Reference: 24.053r06v02

Re: 30-34 Padstow Parade & 10 Faraday Road, Padstow – Proposed Mixed-use Development (SSD-71454709-Mod-1)
Response to Canterbury Bankstown City Council Submission to the State Significant Development Application, 30-34 Padstow Pde and 10 Faraday Rd, Padstow

CARPARK RAMP GROUND FLOOR PLAN

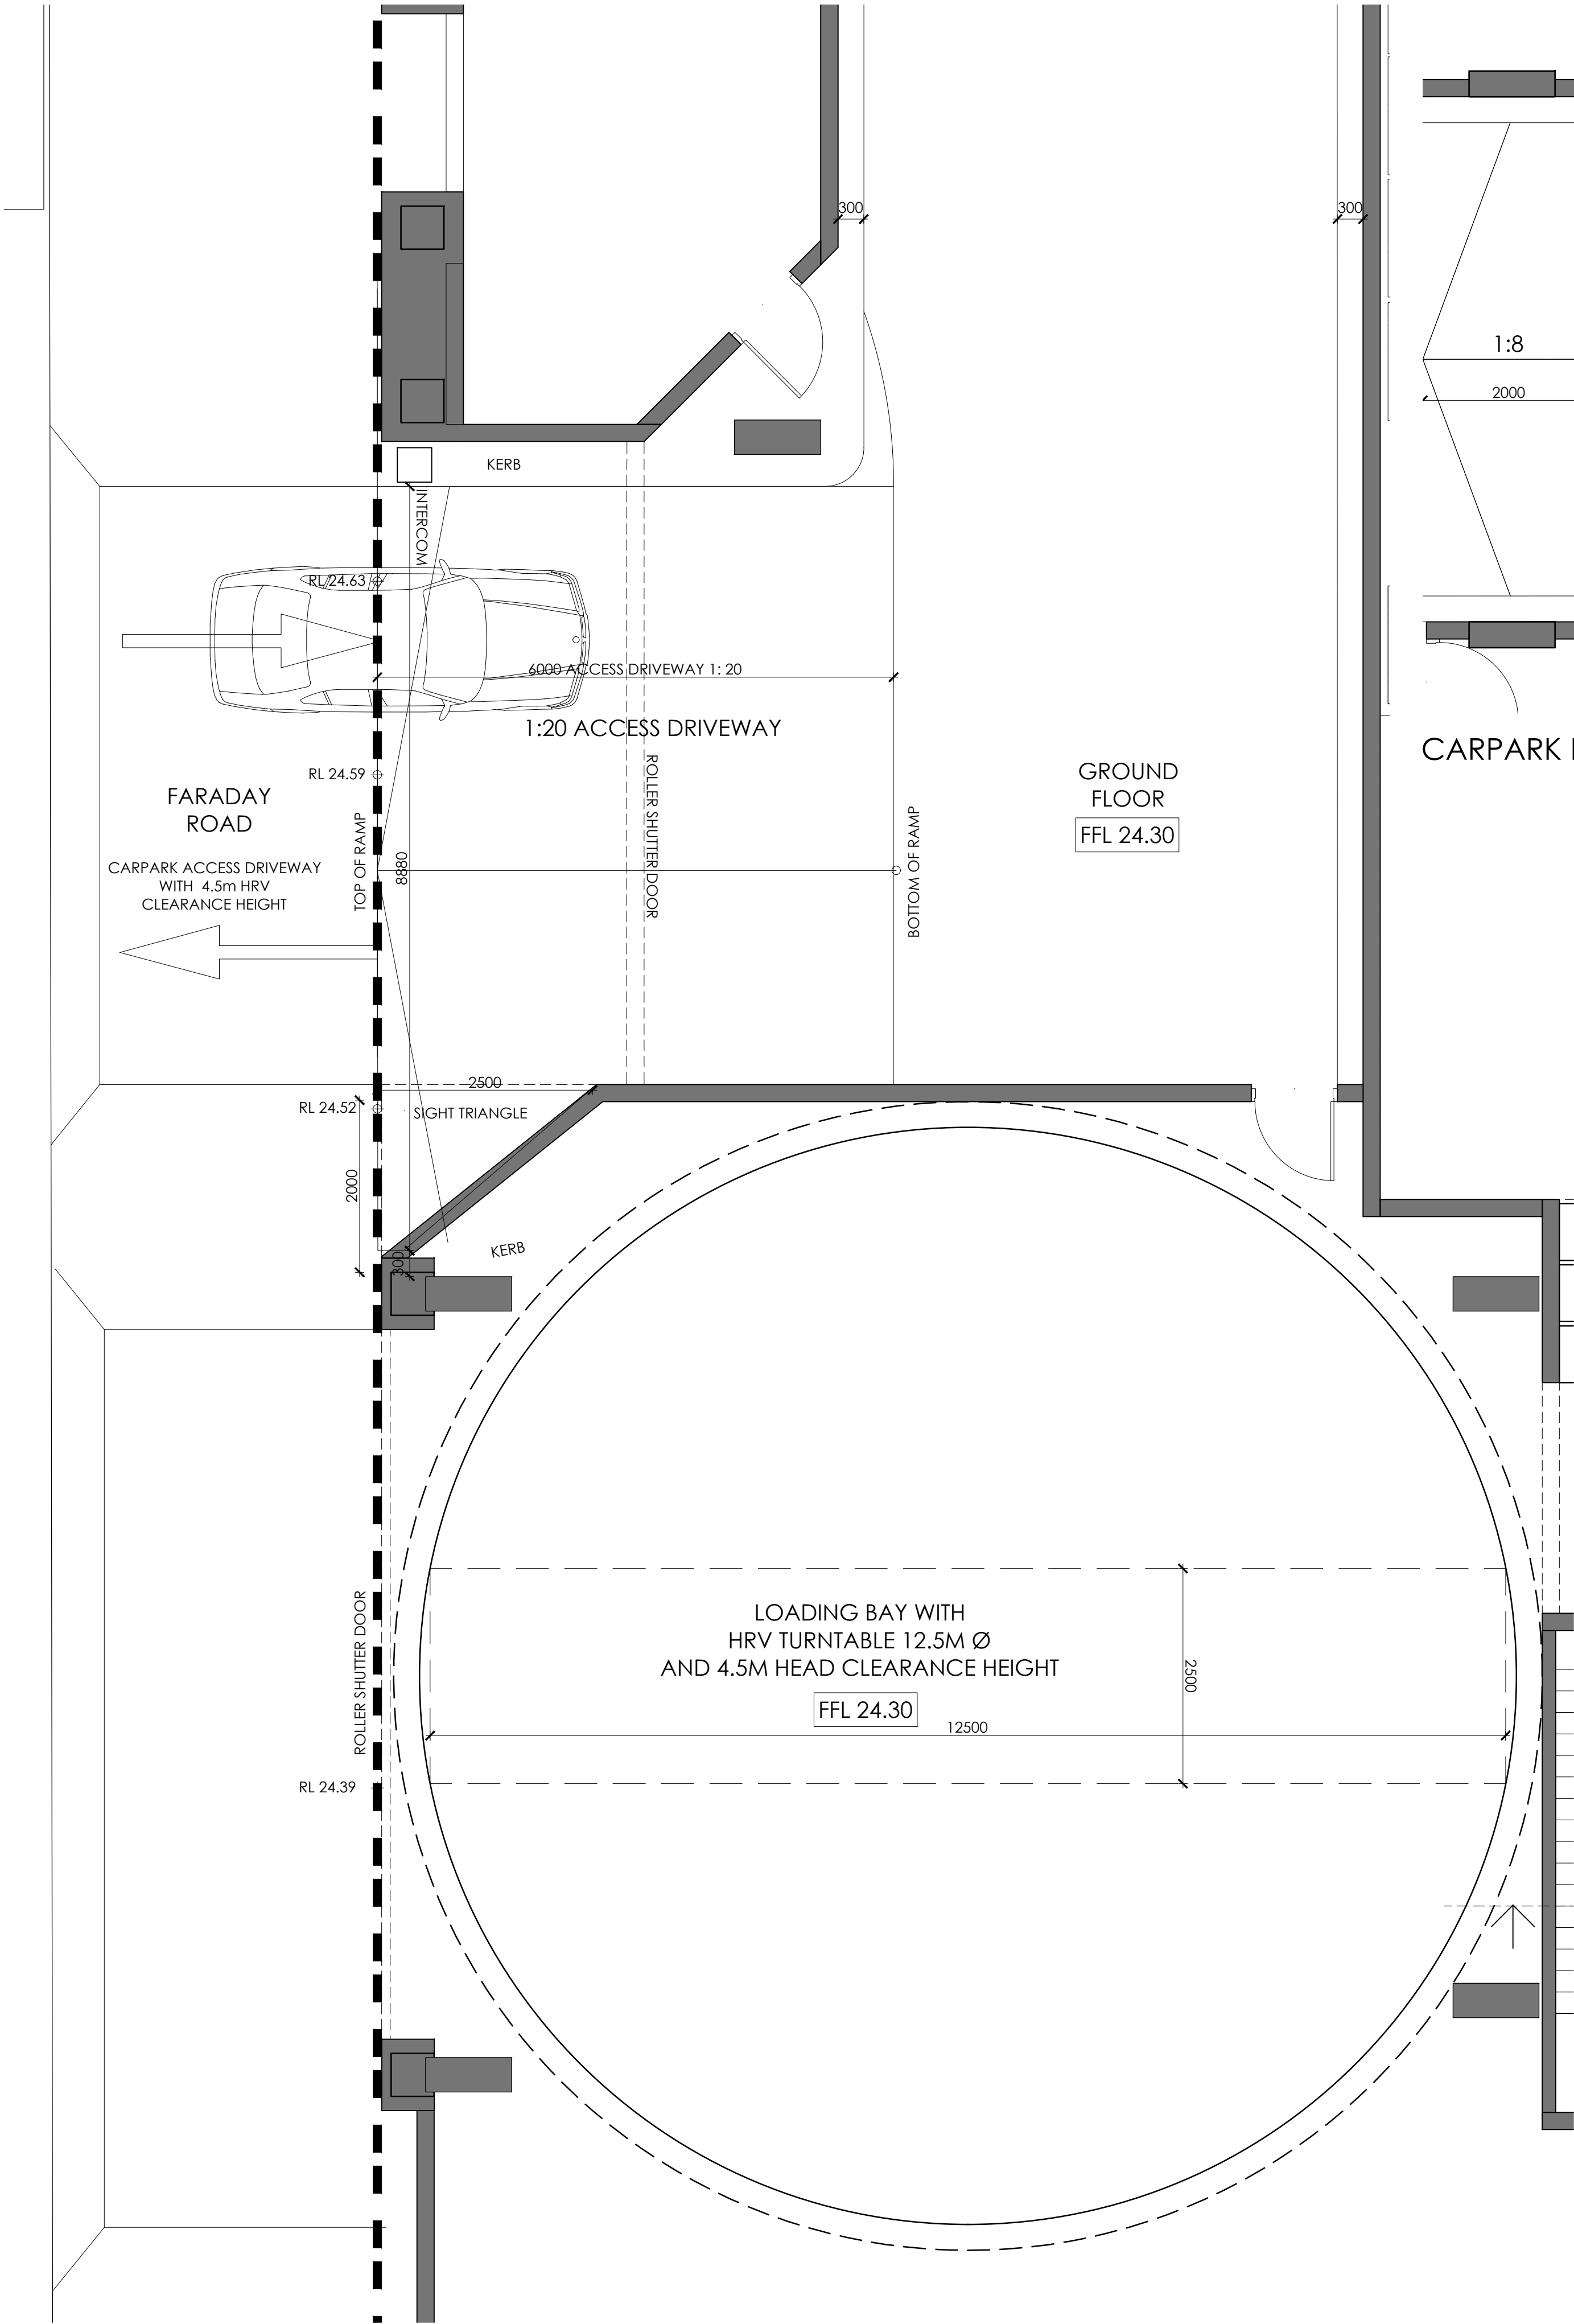
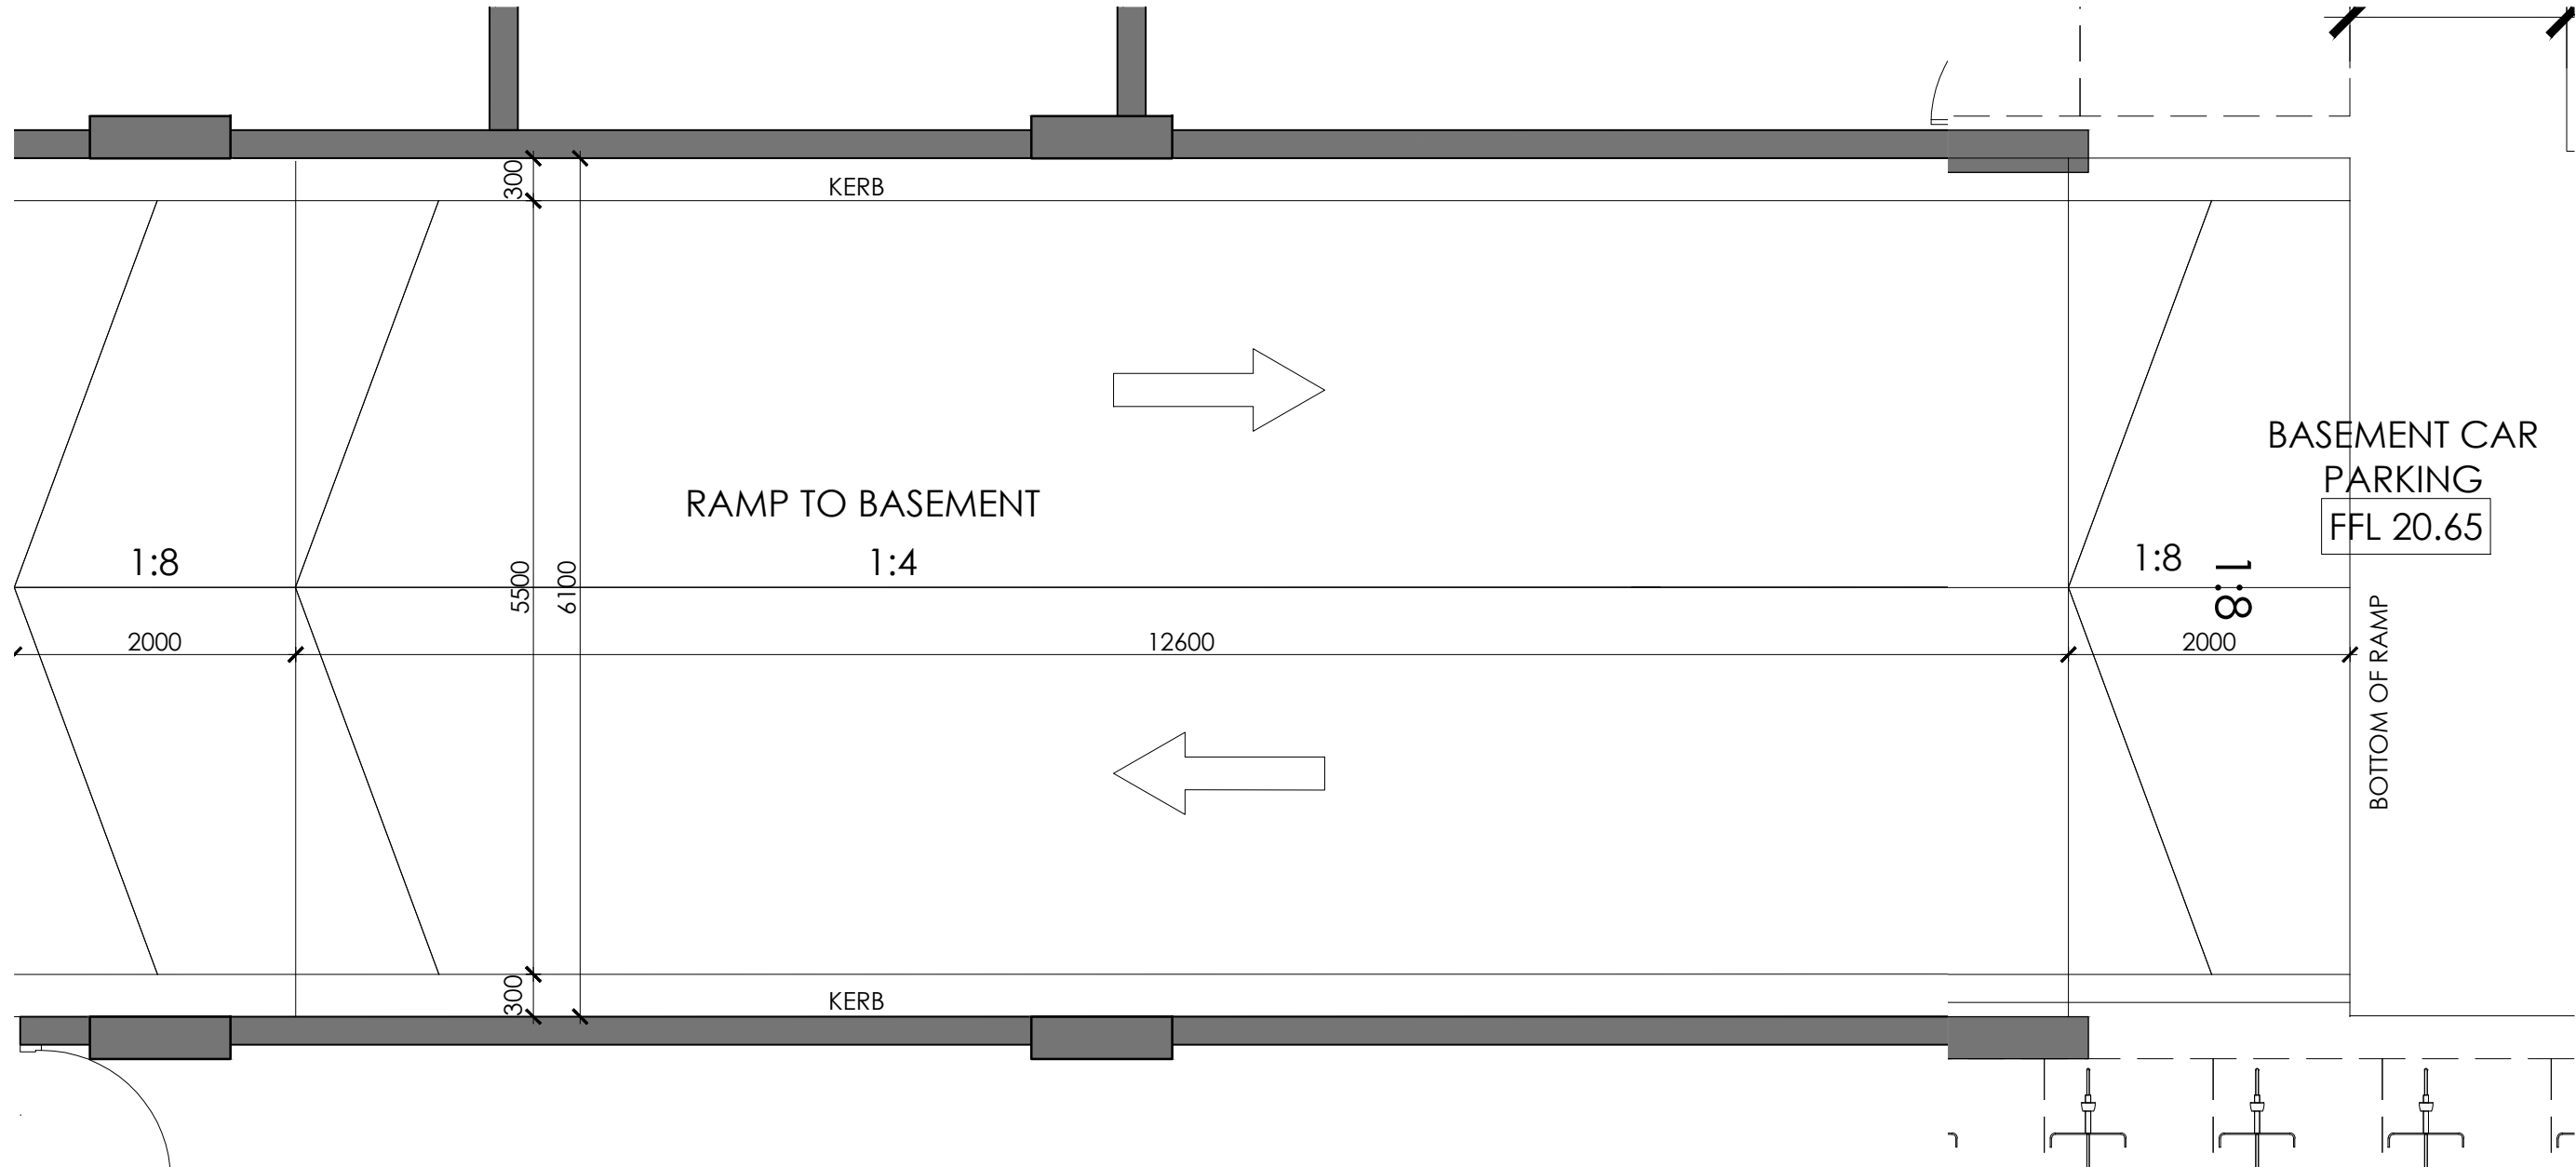
“The turning in and out of car space R1 requires further analysis”

- *"B99 vehicles will not be able to access the basement ramp from the proposed VFC without utilising the entire circulation roadway width, as opposed to staying within designated lanes within the circulation roadway. This fails to comply with AS2890.1 regarding provision of passing opportunities for B85 and B99 vehicles simultaneously."*
- *"Although the circulation roadway has been geometrically designed in accordance with AS2890.1 for two-way traffic flow, our swept path analysis suggests that it can only function as a one-way circulation roadway."*
- *"For reference, a similar swept path was conducted for the originally approved layout which presents a much different scenario with the B99 vehicle being able to access the basement ramp using the allocated lanes."*

- *"The traffic report has failed to provide details on traffic management between the VFC and basement ramp on the ground level and the traffic measures to be implemented to manage two-way traffic flow being funnelled into a one-way circulation roadway."*

- *"The proposed tree planting near the proposed carpark VFC shall be removed to allow for better manoeuvrability of B99 vehicles into the VFC without encroaching onto the other side of the VFC for approach vehicles."*

- *"The proposed roller shutter door, which is a vehicular control point, has been shifted further towards the proposed VFC in comparison to the approved plans. This will result in loss of internal queueing space within the ground floor. Therefore, queueing analysis will need to be conducted to ascertain the impacts along Faraday Road which shall be provided in the traffic report with comparison between the proposed and approved plans."*

- *"The proposed intercom location is located on the passenger side of vehicles entering the carpark through the roller shutter door entrance. This is not practical; it needs to be located on the driver side."*

Space R1 has been provided as a User Class 1A parking space with a minimum width of 2.4 metres in accordance with Figure 2.2 and Figure 5.2 of AS2890.1 (2004) and fully complied with the Standard in this regard. It is confirmed that the roller door adjacent to the parking space will be activated and in the opened position when the resident is manoeuvring into and out of parking space R1 and the roller door will not provide an obstruction in terms of manoeuvrability in this regard. As such, car space R1 complies with AS2890.1 (2004) and will operate satisfactorily.

Reference should be made to the swept path analysis presented in **Attachment 1** showing that adequate passing opportunities have been provided within the property boundary at the access driveway and at the top of the internal ramp. This arrangement will allow drivers to sight passing traffic and to pass within the circulation roadway as demonstrated. Furthermore, the internal circulation roadways have been designed with a minimum width of 6.1 metres measured wall to wall and 5.1 metres measured kerb to kerb which is sufficient to accommodate two-way traffic flow in accordance with Clause 2.5.2 of AS2890.1 (2004).

It is emphasised that the circulation roadway operates as a two-way circulation roadway in accordance with AS2890.1 (2004) with adequate passing opportunities provided as stated in response to Item 1. Nevertheless, to assist with sighting of passing vehicles, a convex mirror can be provided on the wall opposite the top of the ramp on the Ground Floor level to assist with sighting of oncoming vehicles, if required.

Reference should be made to the swept path analysis presented in **Attachment 1** showing a B99 turning into the vehicular driveway from Faraday Road with sufficient clearance provided to the proposed tree planting.

The proposed roller shutter door will remain open throughout the day permitting access for residents, visitors, and customers to the site. However, at night the shutter door will remain closed, with residents able to open the door via remote control and there being no requirement to queue to activate the roller door. As such, queuing is not expected to occur.

The vehicle control point will not be used manually under normal conditions because after hours the roller door will remain closed and can only be activated by residents with a remote FOB. The intercom is only expected to be used as a back up option in the event the remote FOB is not working, and drivers are required to manually swipe the FOB at the vehicle control point. However, such a requirement is expected to be a rare occurrence and not typical of normal conditions.
